From: Thomas Callaway
Sent: 03 September 2014 14:42
To: Planning.Responses
Subject: RE: Planning Consultation on LU/253/14/DOC

APPLICATION NO: LU/253/14/DOC

Site Address: Courtwick Lane Land south of railway Littlehampton BN17 7PD

Description of Works: Application for approval of details reserved by conditions 8 (surface water drainage), 9 (discharge of water flows), 10 (foul drainage), 17 (Construction Method Statement), 18 (construction compound), 20 (vehicle wheel cleaning), 22 (specification of layout for roads, footpaths, cycleways and parking areas), and 29 (materials and finishes) following a grant of planning permission LU/355/10/.

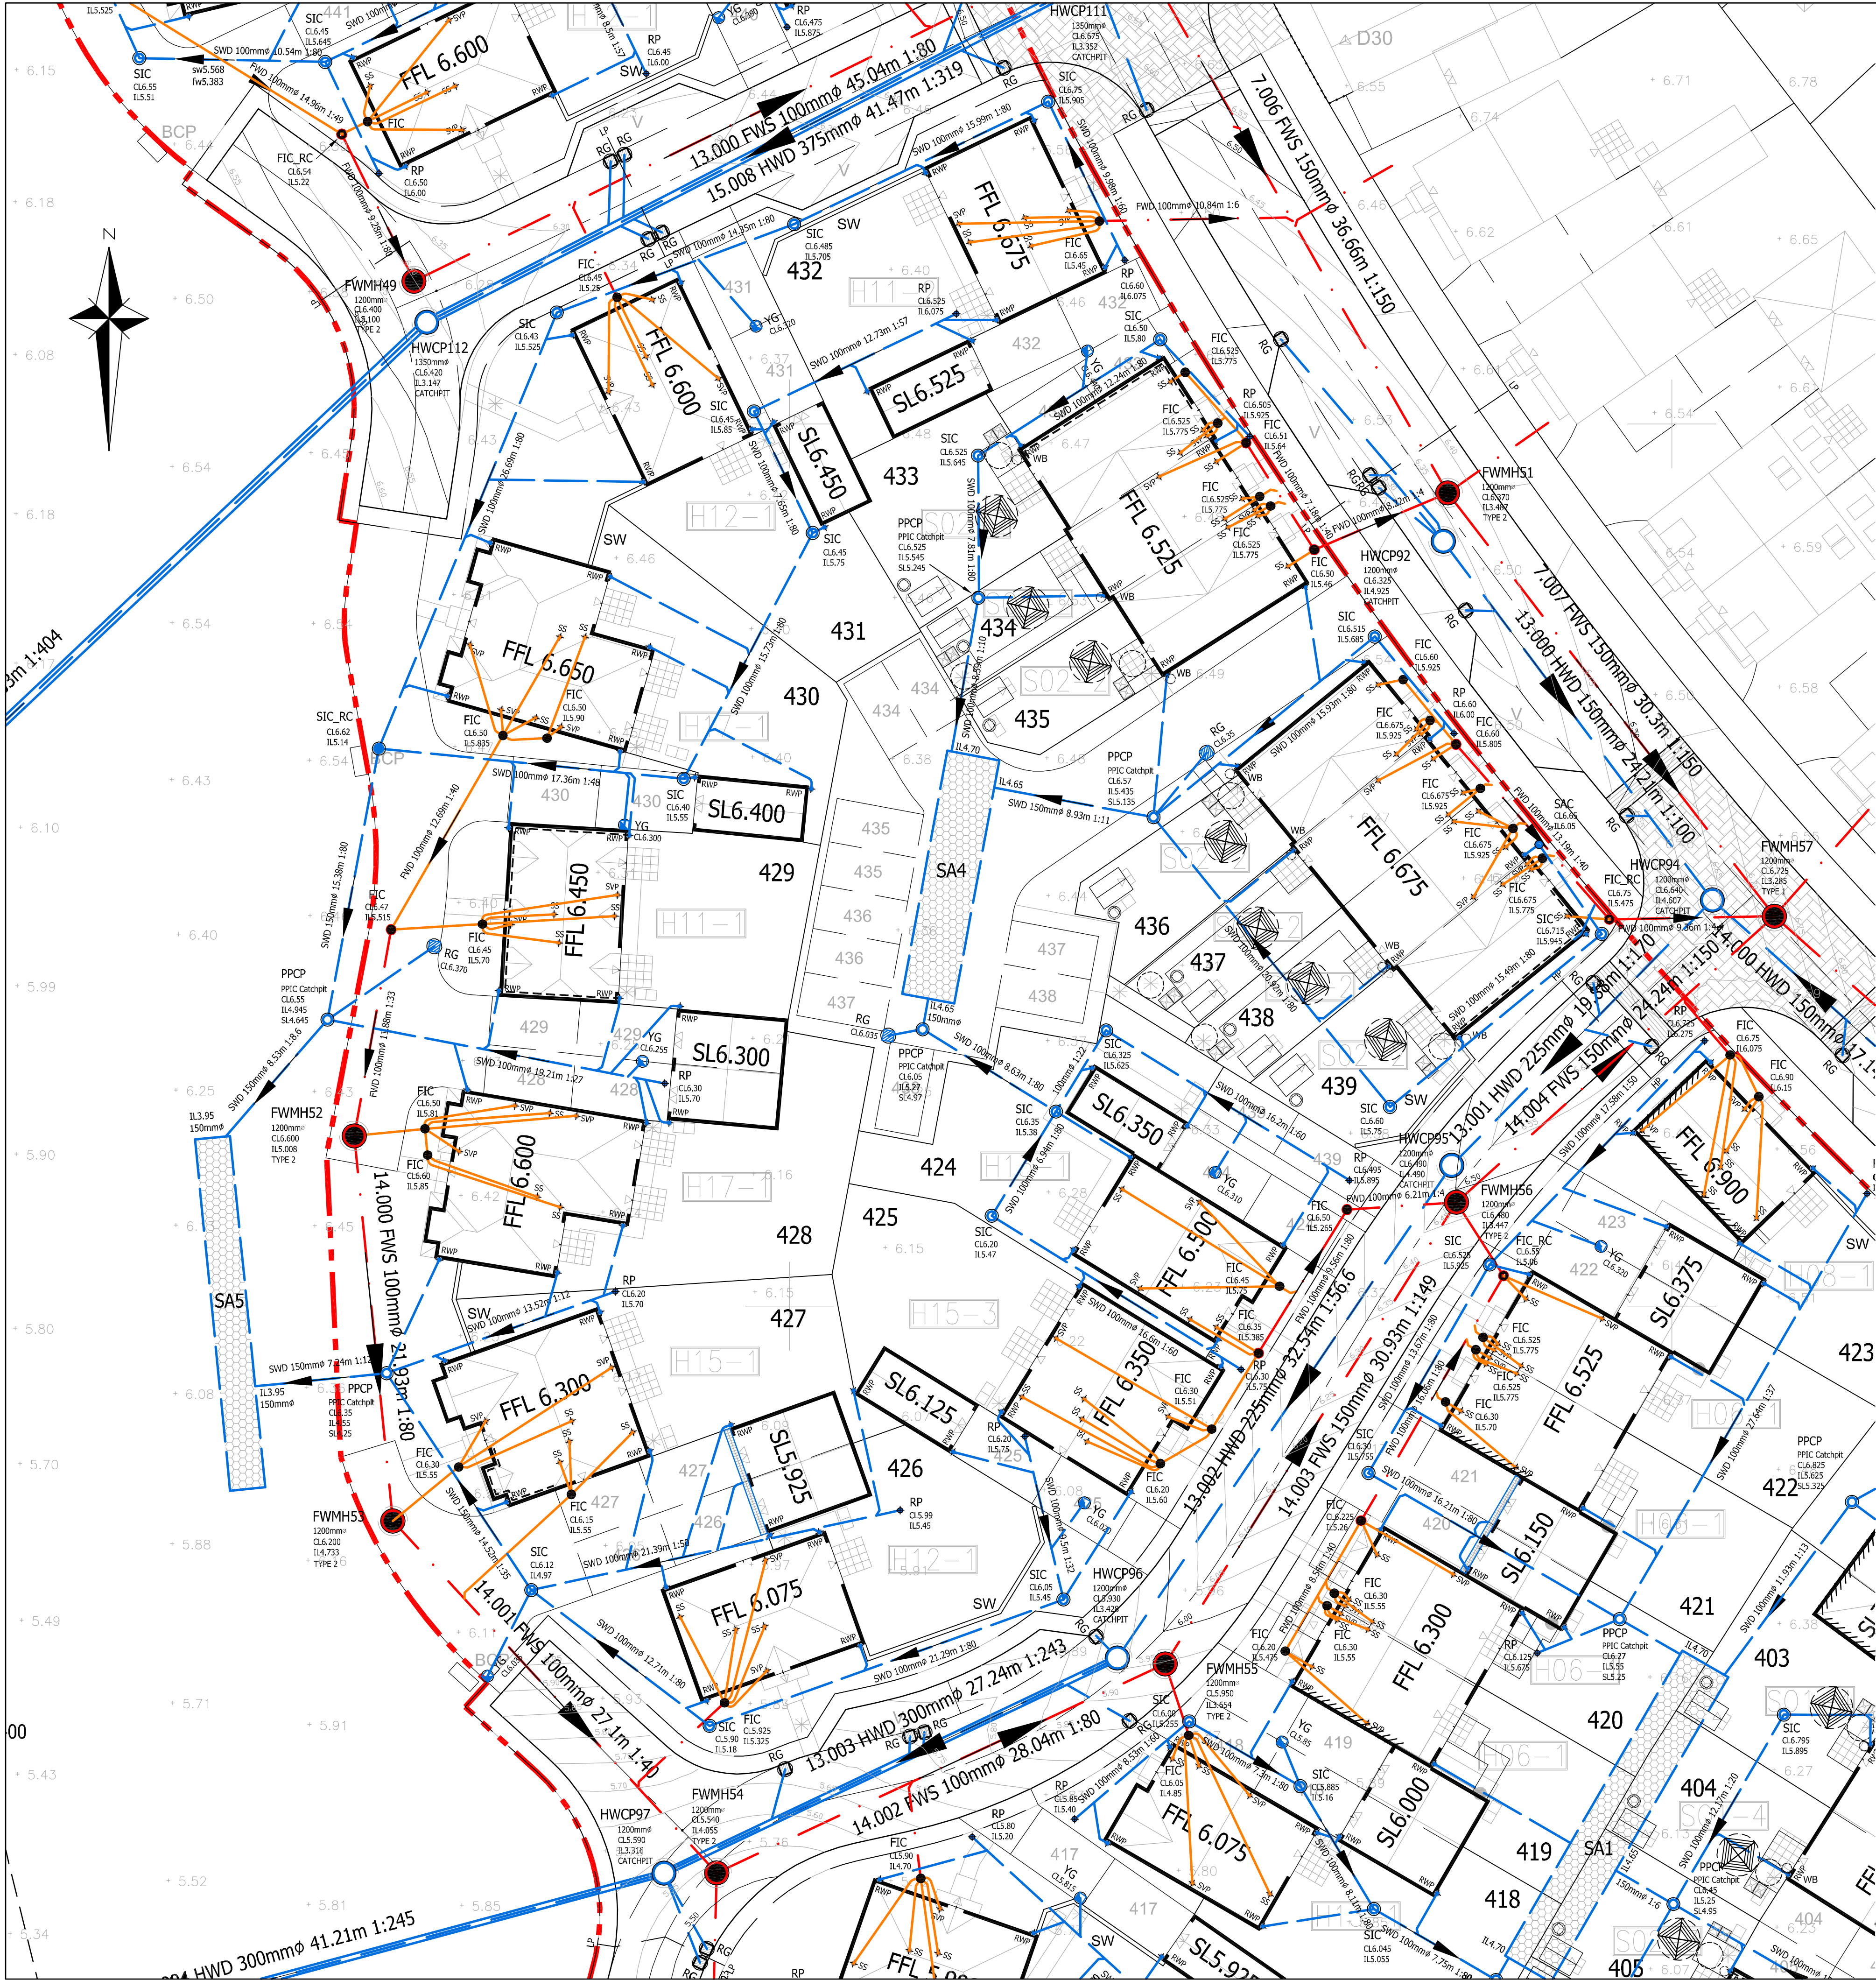
Could calculations be provided for the soakaway inflow – results seem to show that most proposed soakaways tend to be suitable for the 1 in 100 year storm event but do not account for an extra 30% on top of rainfall intensity. I was checking using the BRE 365 method, it may be possible that the soakaway sizes were calculated allowing for infiltration through sides and base. Please could this be confirmed with the numbers/calculations included. The method used to design the soakaways should be consistent with the method used to undertake the percolation tests. More storage may be required in the soakaways.

The EA referenced storing the 1 in 100 year storm event plus 30% in their consultation response letter dated 12/1/11 (LU/355/10), as a figure to determine that the proposal will not increase flooding elsewhere. It is also a figure that we now use for all development proposals.
